COMMENT RESPONSE LETTER

RE: 2401-129  
5330 LANSDOWNE LANE

SITE PLAN

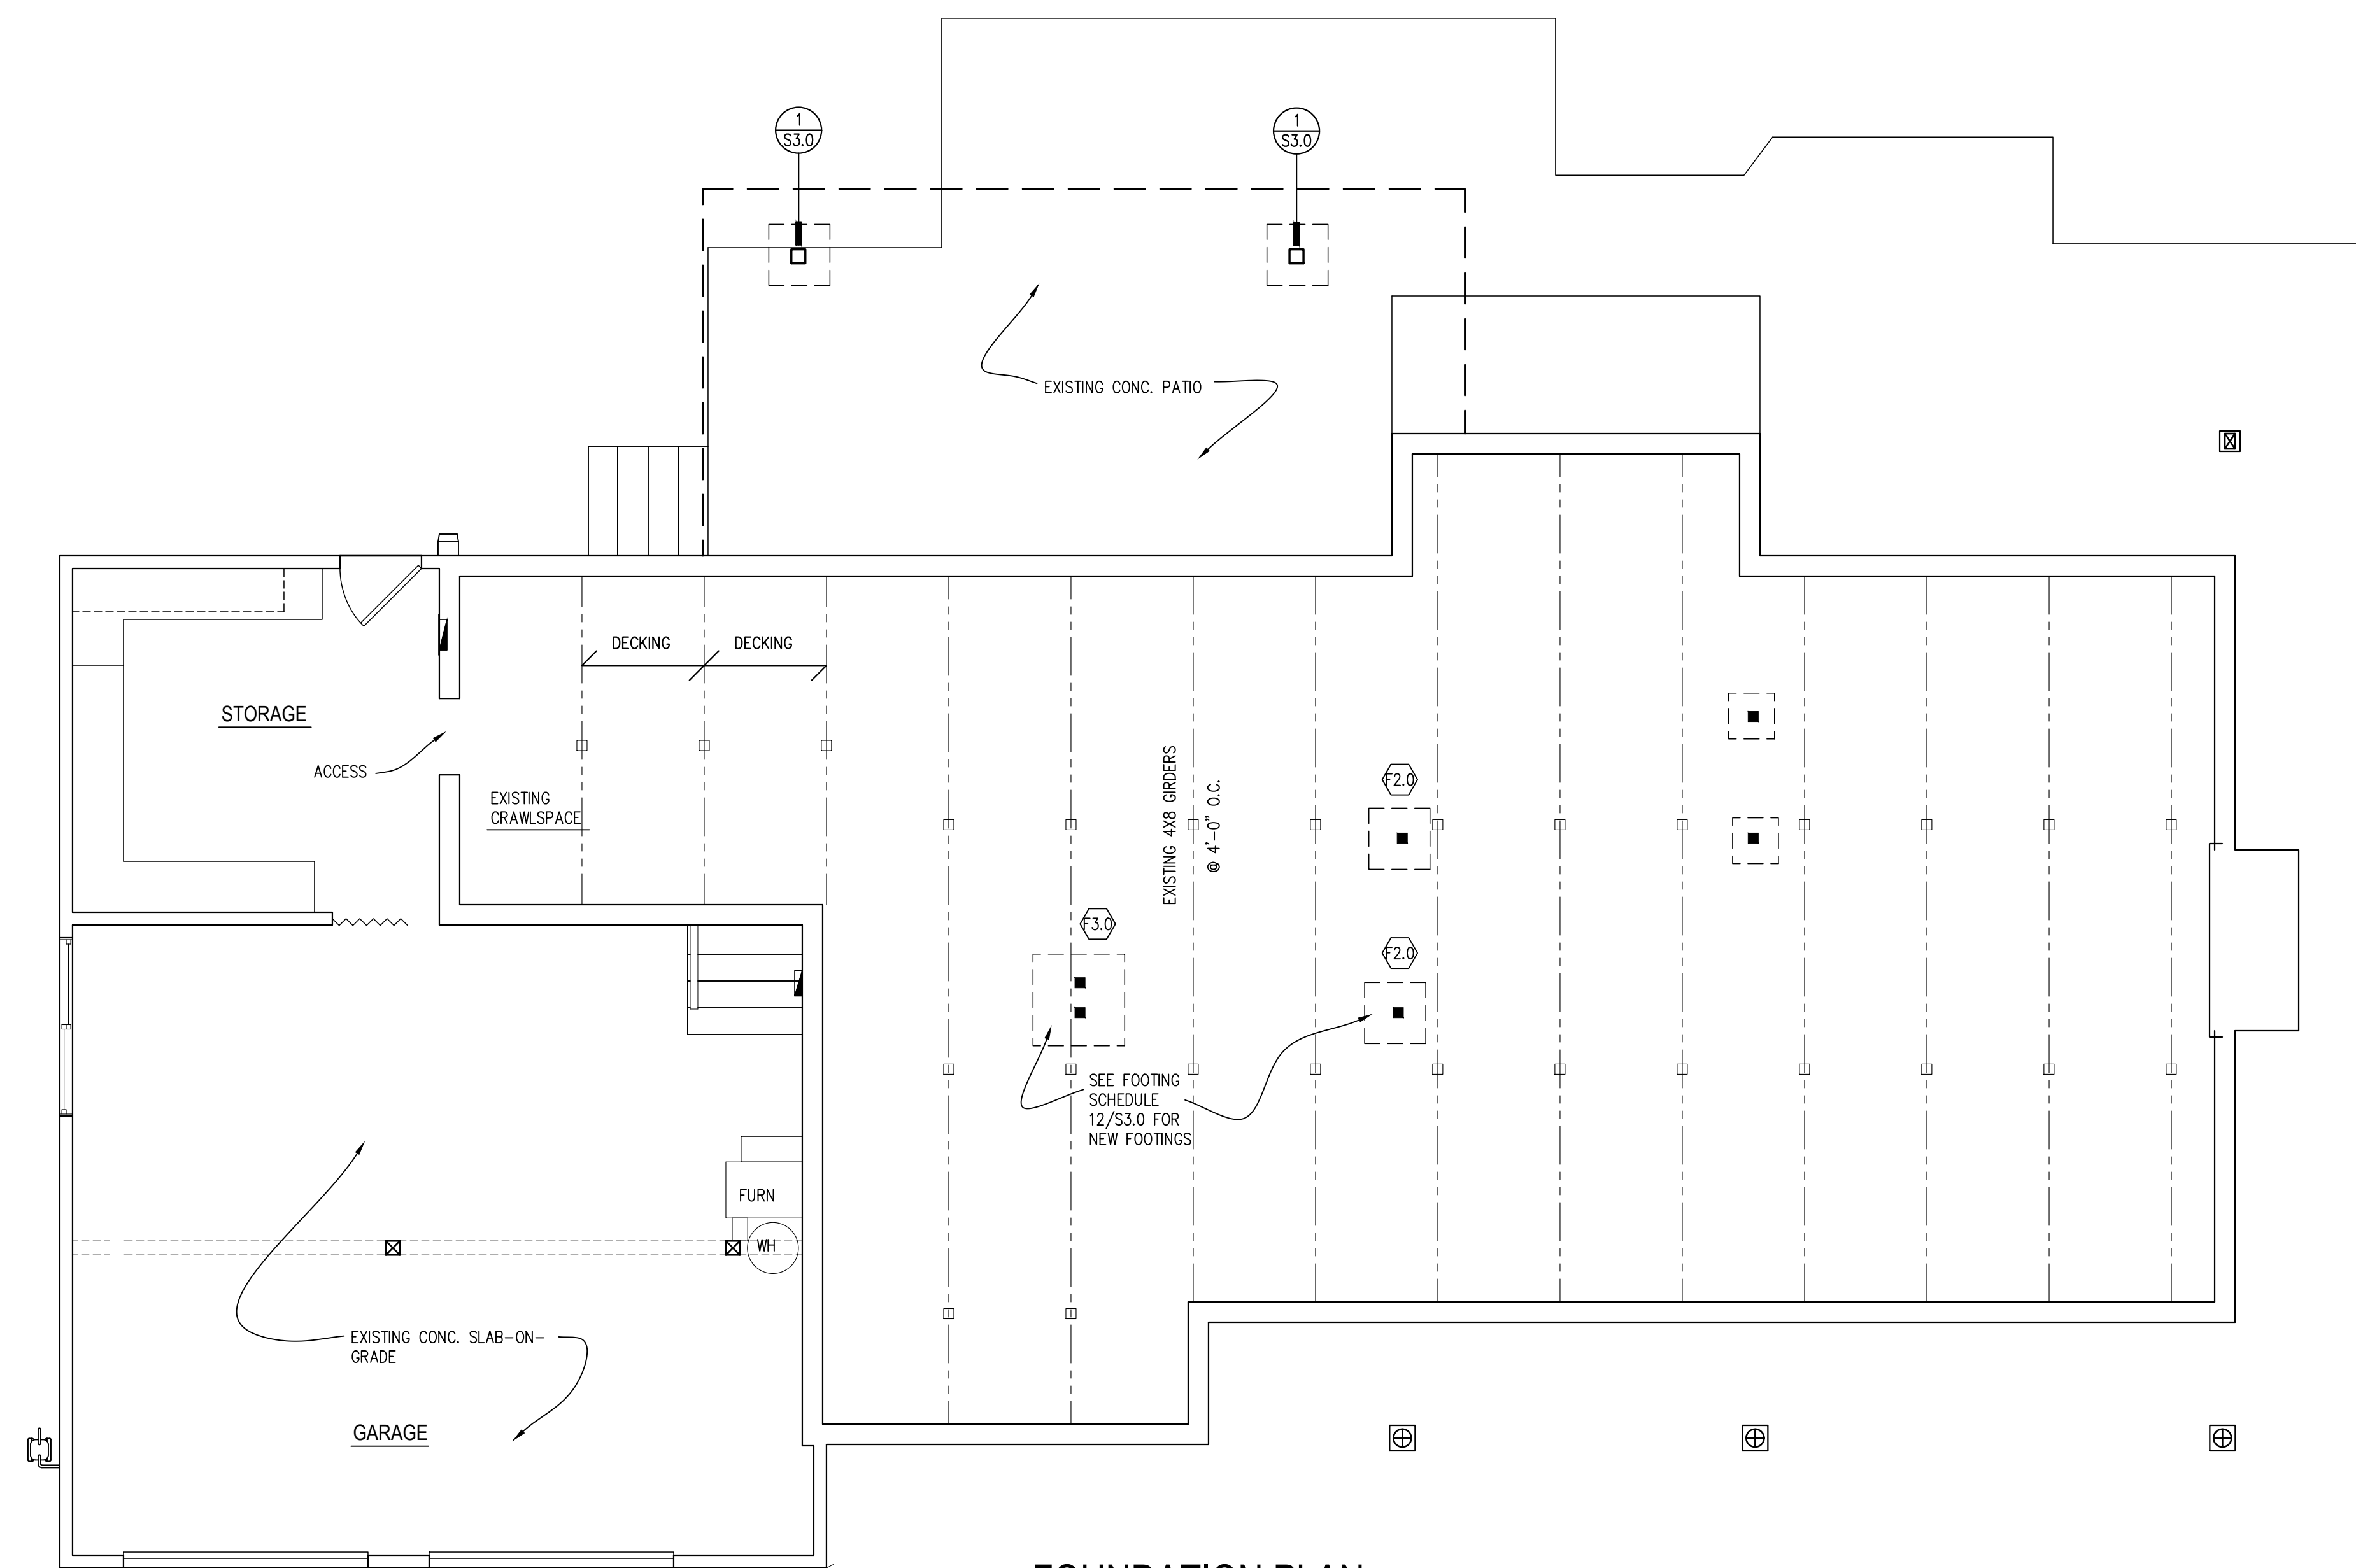
1. Soil bearing has been revised to coordinate with structural
2. Setbacks are labeled on the site plan
3. Math errors have been fixed
4. Patio removed from hardscape
5. The OFFICE has been relabeled SLEEPING ROOM
6. Make-up air note added to appliance schedule sheet 3.1
7. Smoke detectors and carbon monoxide detectors are shown
8. Spaces where no work is to occur are labeled.
9. Fans are shown
10. No 12' ceilings.
